A585 Windy Harbour to Skippool Improvement Scheme

TR010035

7.11 Environmental Statement Changes and Corrections Document

Version	Date	Status of Version
Rev 0	May 2019	Deadline 2 Submission
Rev 1	July 2019	Deadline 4 Submission

APPENDIX C – Updated Figure 9.10 Photomontage at viewpoint location 2, view from residential properties on Breck Road, Photomontage at Viewpoint Location 9, view from Footpath 5-11-FP 2 at Junction with A585 Garstang New Road and Photomontage at viewpoint location 10, view from the B5260 Lodge Lane

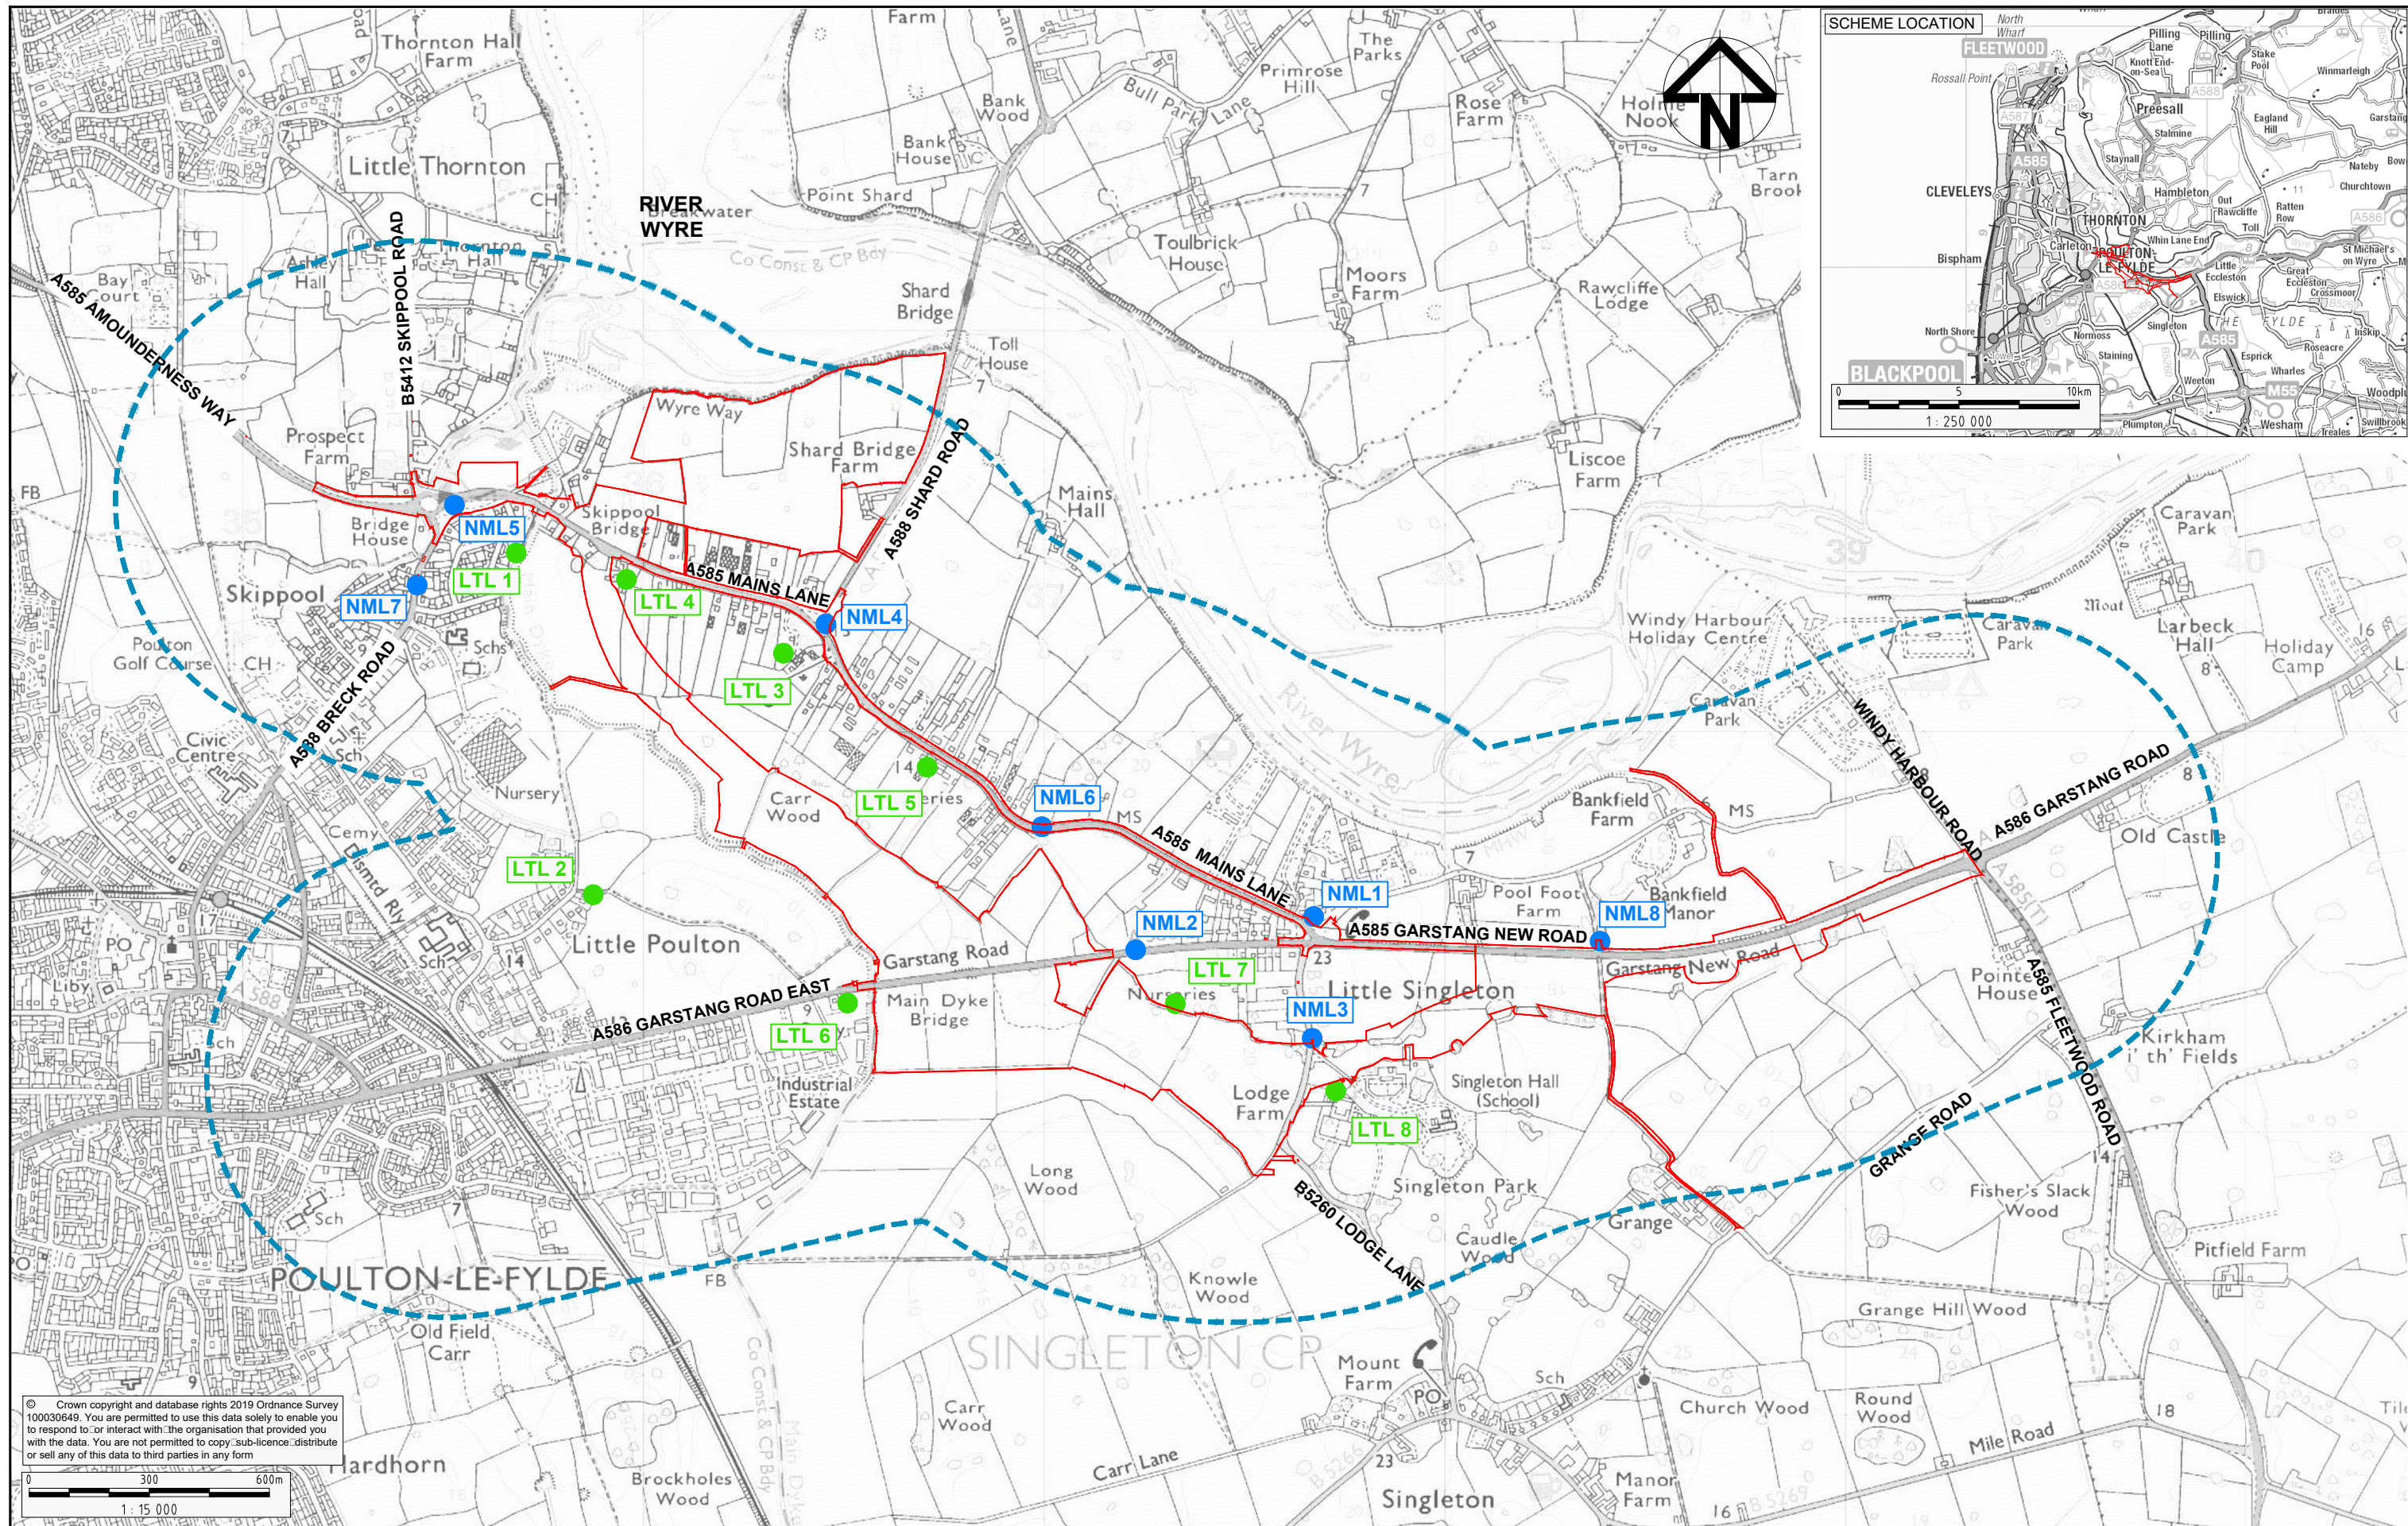
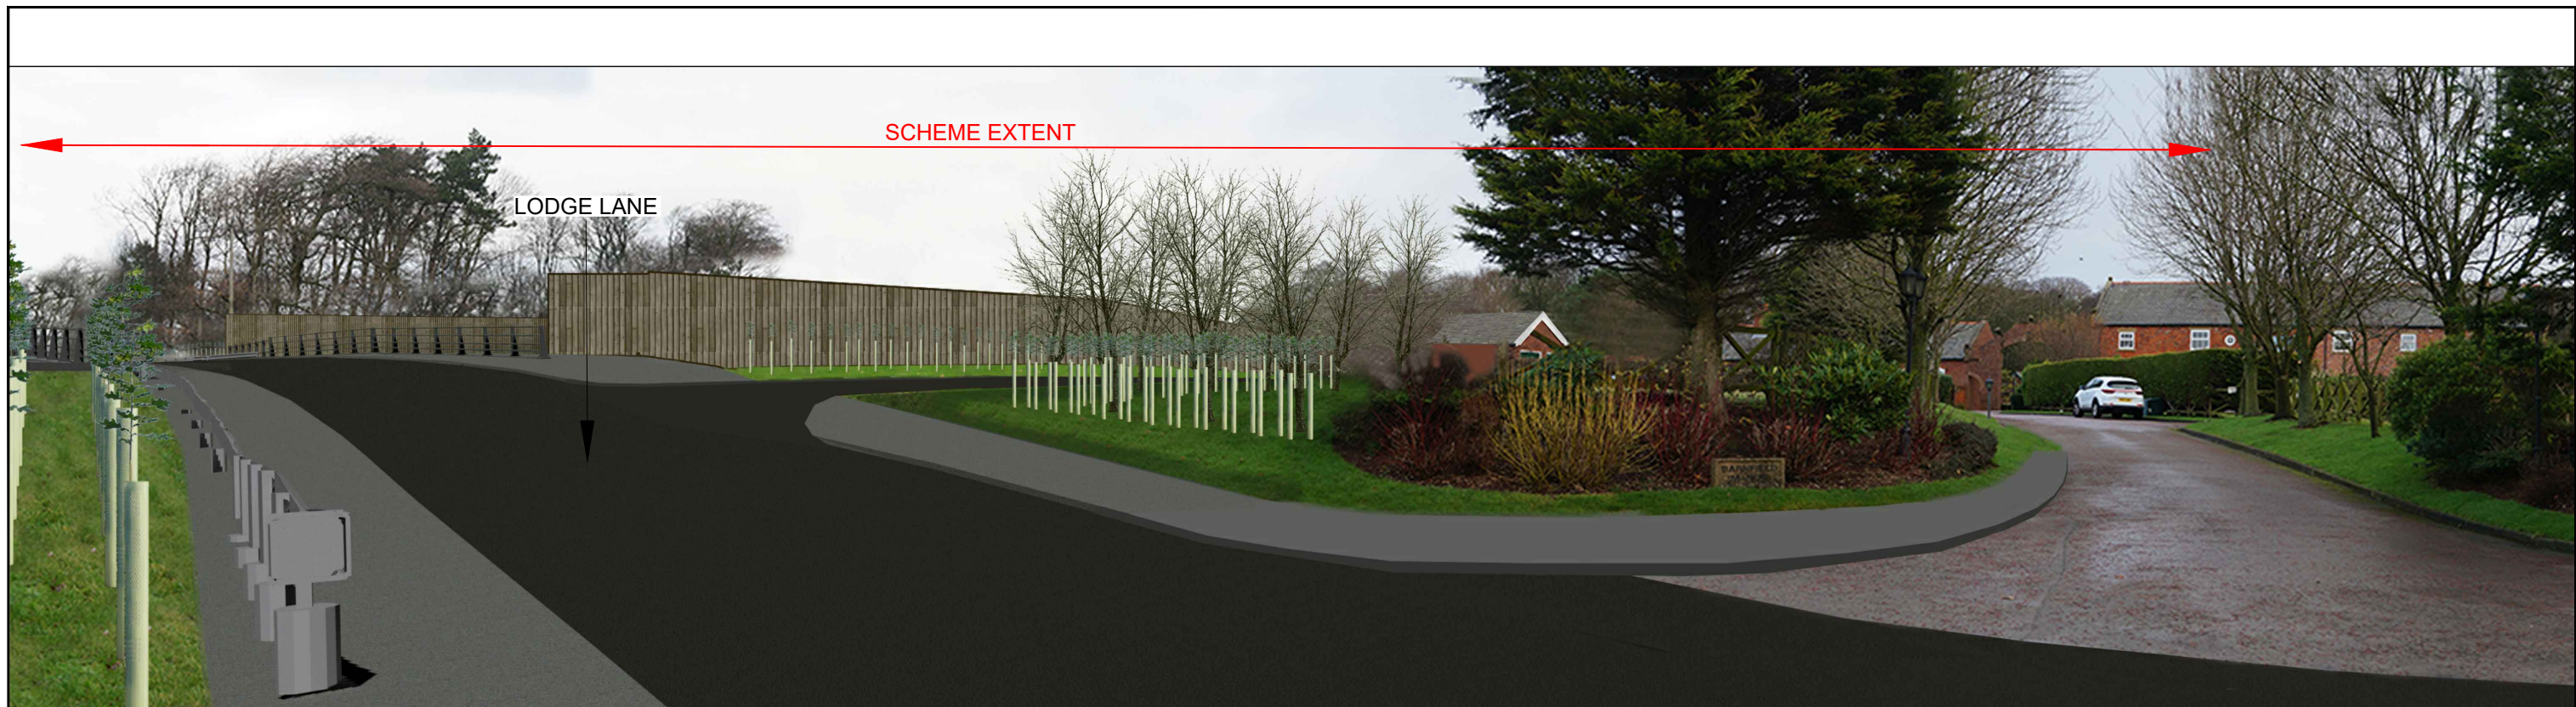
Document Reference Number	Document Name	Amendment Required			Reason									
6.9	ES Chapter 9: Landscape	Update to Figure 9.10, Photomontage at viewpoint location 2, view from residential properties on Breck Road provided within Appendix C.			As a result of updates to the Flood Risk Assessment associated with the dwarf wall.									
6.9	ES Chapter 9: Landscape	Update to Figure 9.10, Photomontage at viewpoint location 10, view from the B5260 Lodge Lane provided within Appendix C.			Updated to show the 3m high acoustic barrier to the north of the cutting.									
6.9	ES Chapter 9: Landscape	Update to Figure 9.10, Photomontage at viewpoint location 9, view from the A585 Garstang New Road provided within Appendix C.			Updated to show the additional linear planting adjacent to Grange Footbridge, as a result of request from Fylde Borough Council (document reference TR010035/APP/7.9).									
6.9	ES Chapter 9: Landscape	Update to Table 9-16

APPENDIX D – Updated Figure 11.1: Noise and Vibration – Noise Monitoring within the Study Area and Figure 11.4: Noise and Vibration – Noise Mitigation

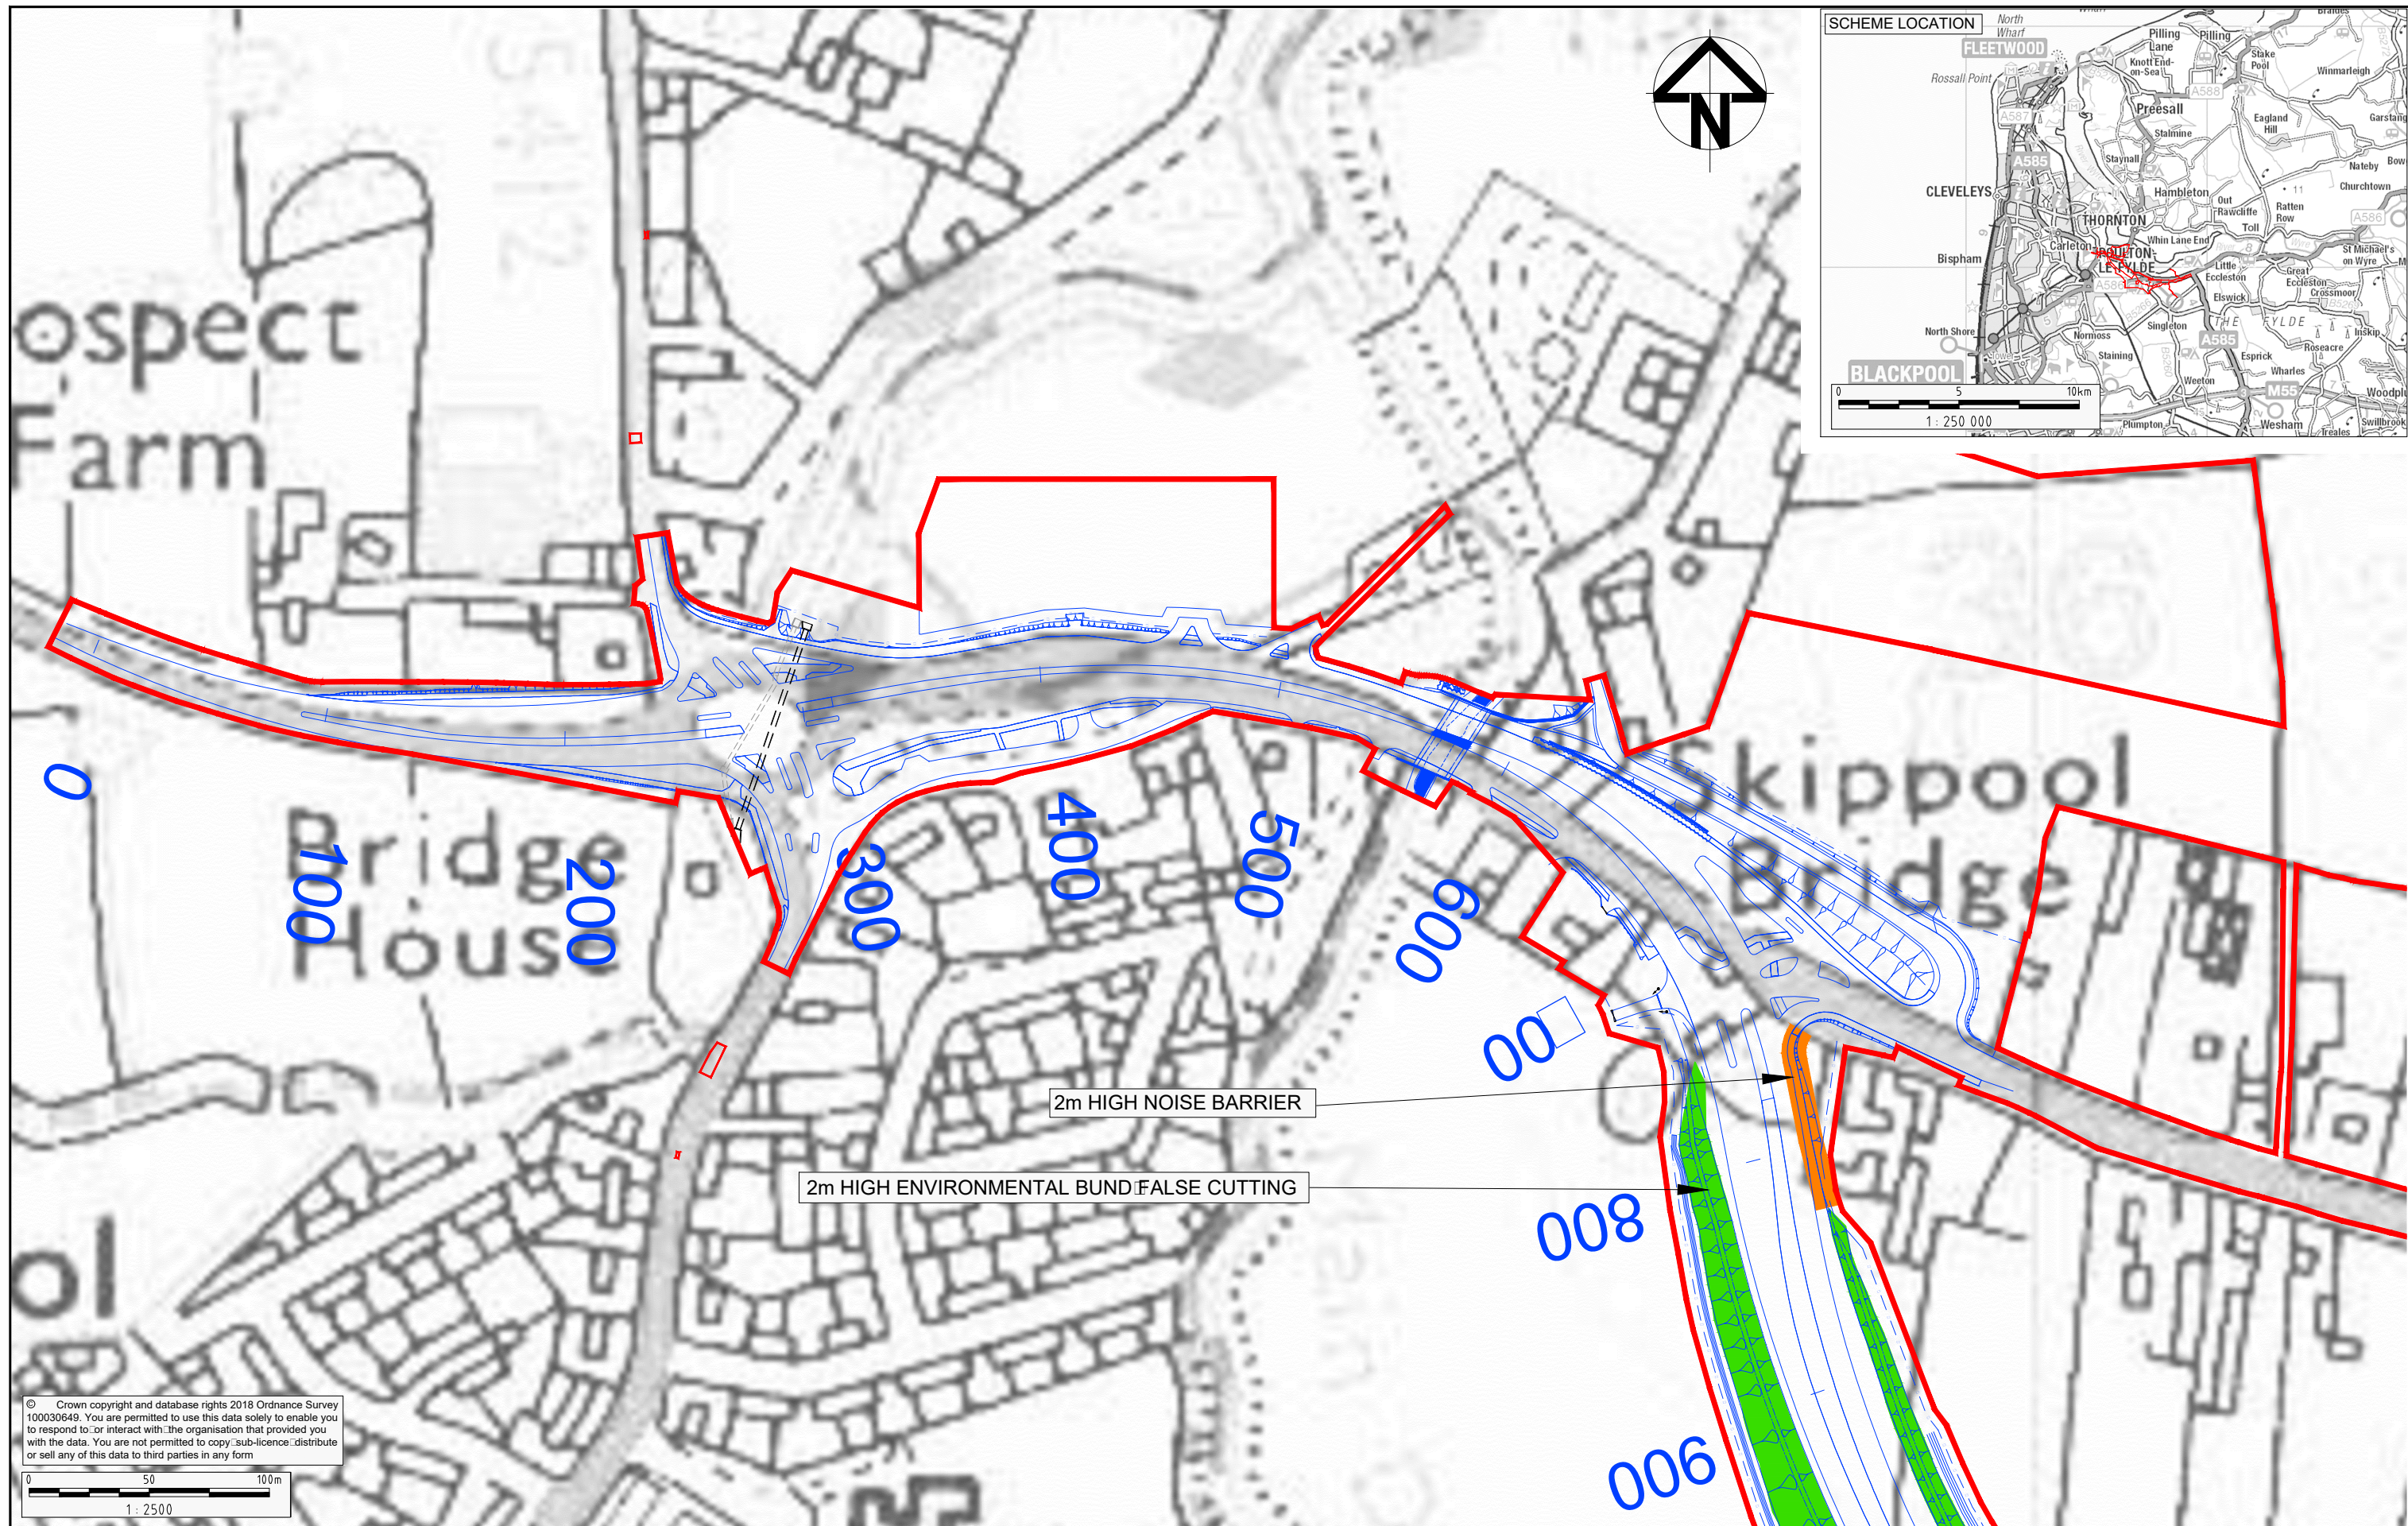
6.11	ES Chapter 11: Noise and Vibration	Update to Figure 11.1: Noise and Vibration – Noise Monitoring within the Study Area presented at Appendix D to show the locations of the eight attended noise surveys.	Requested by the Inspector within the first round of written questions (document reference
